General	
GEN2.7	At D2 the Applicant submitted an update to the Rights of Way and Access Plan [REP2- 003]. This was updated to address comments made by NCC at D1. What are NCC's comments on the updated plan?	The Council supports the updated Rights of Way and Access Plan and has no further comments to make at the present time.
	Air Quality	
AQ2.2	Is NCC content that the Proposed Development will not significantly increase the levels of air pollution within the wider area by increasing the number of vehicles?	<p>Baseline levels from DEFRA background maps for thirty-five of the nearest receptors (ten in Part A and twenty-five in Part B) shows the existing background levels of the following atmospheric pollutants;</p> <p>Nitrogen Dioxide (NO₂) – 6 to 33 µg/m³, and; Particulates 10 and 2.5 micron (PM₁₀ / PM_{2.5}) – 8 to 24 µg/m³.</p> <p>The modelling of nitrogen dioxide (NO₂) impacts for thirty-five human receptors has shown that the difference between Do-Minimum (without dualling) and Do-Something (dualling of the two sections as proposed) results in an increase of 1.0 microgramme per cubic metre (µg/m³) or less for the opening year (2023) for the majority of receptors. Only one recept

**Trees to be Removed and Replaced at Coronation Avenue  
WQ LV.1.8**

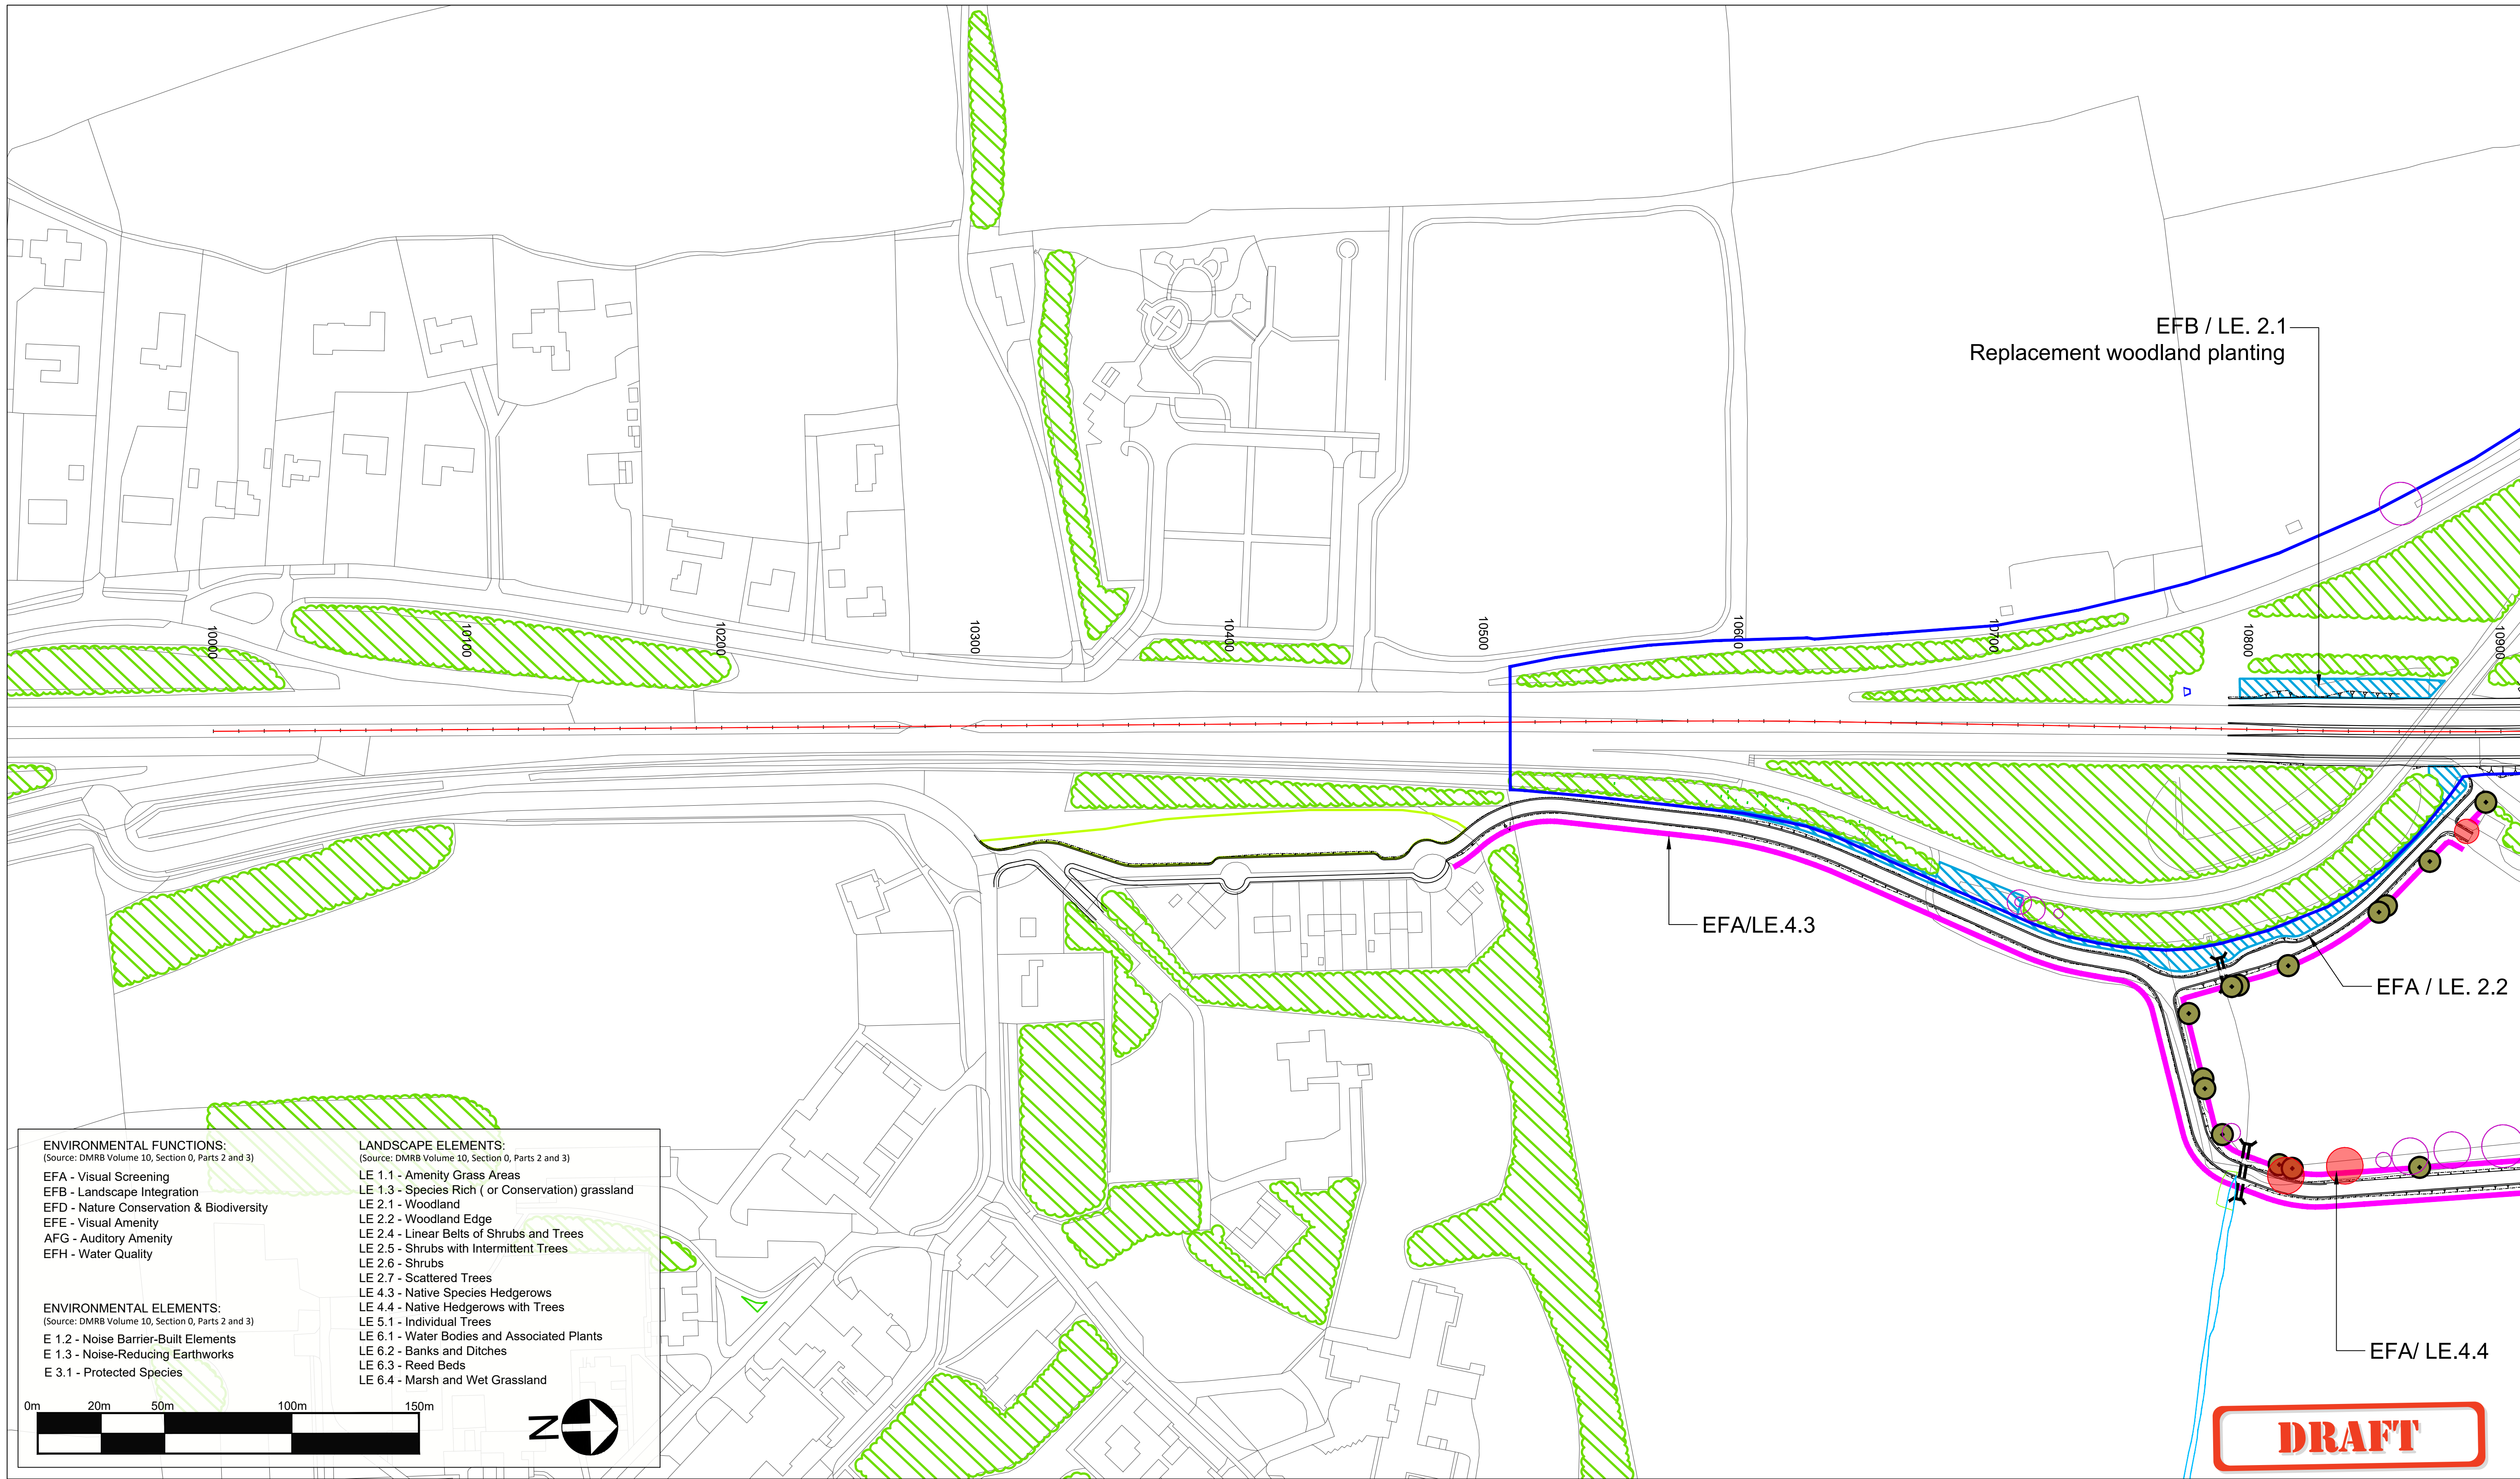
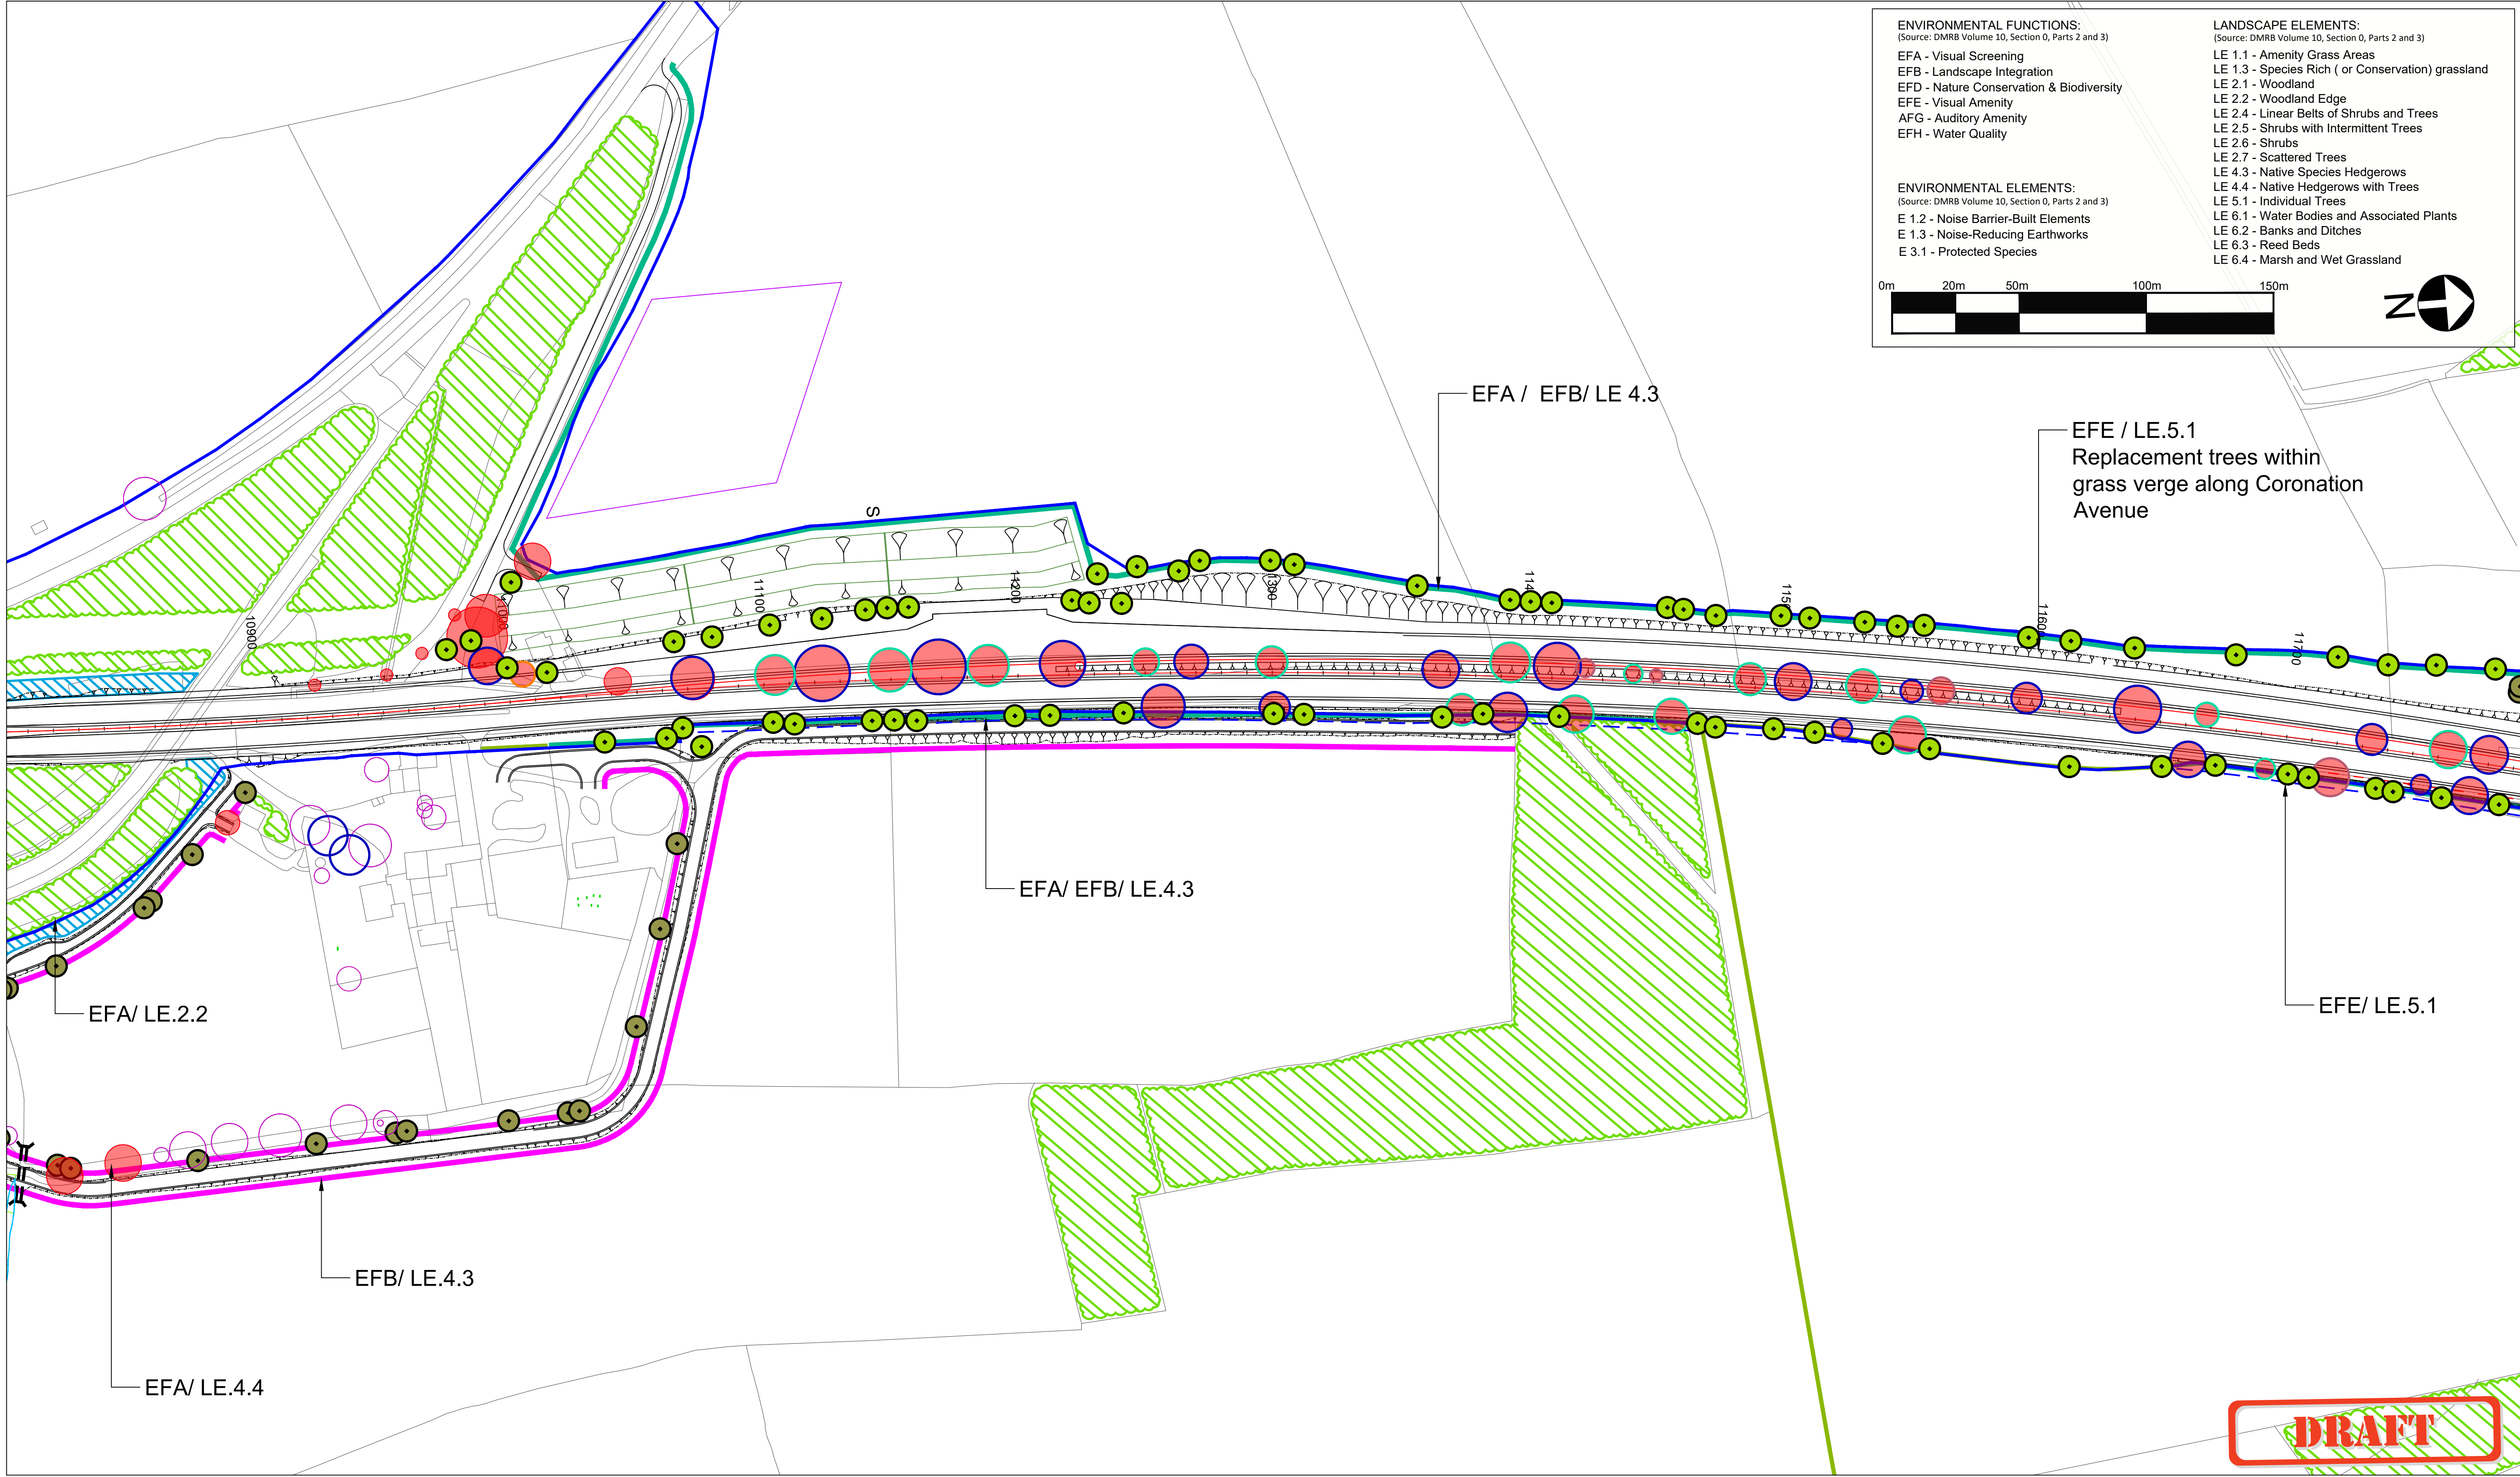
PART 2: no comments to make. The Council has reviewed the changes to Schedule 4 contained in the draft DCO – Revision 4 with respect to public rights of way and supports all of the changes.
	Landscape and Visual	
LV2.2	The plans which form Appendix LV.2 Trees to be Removed and Replaced at Coronation Avenue WQ LV.1.8 [REP1-044] are annotated 'Draft'. The Applicant is asked to explain how this relates to the requirement in R5(3) of the dDCO for the landscaping scheme to include a strategy for the replacement of trees which are to be removed at Coronation Avenue? IPs are asked to comment on the proposals for Coronation Avenue.	The number and location of replacement trees for Coronation Avenue as illustrated on the draft plans are appropriate. These proposals are now also reflected on 6.31 Landscape Mitigation Masterplan – Part A – Rev 2 submitted at Deadline 4.
LV2.6	Appendix LV3 Response to LV.1.13 [REP1-051] considers potential additional mitigation measures, their suitability and the prospect of potentially reducing significant effects to non-significant. What are the views of IPs in respect of these further potential mitigation measures?	Additional mitigation has been discussed and agreed with the Applicant at West Moor and Fenrother junctions and to the west of Causey Park Bridge. This is reflected on 6.31 Landscape Mitigation Masterplan – Part A – Rev 2 submitted at Deadline 4. This represents a welcome improvement in the landscape mitigation proposals although NCC agree with the assessment provided by the Applicant that the previously identified significant effects would remain.
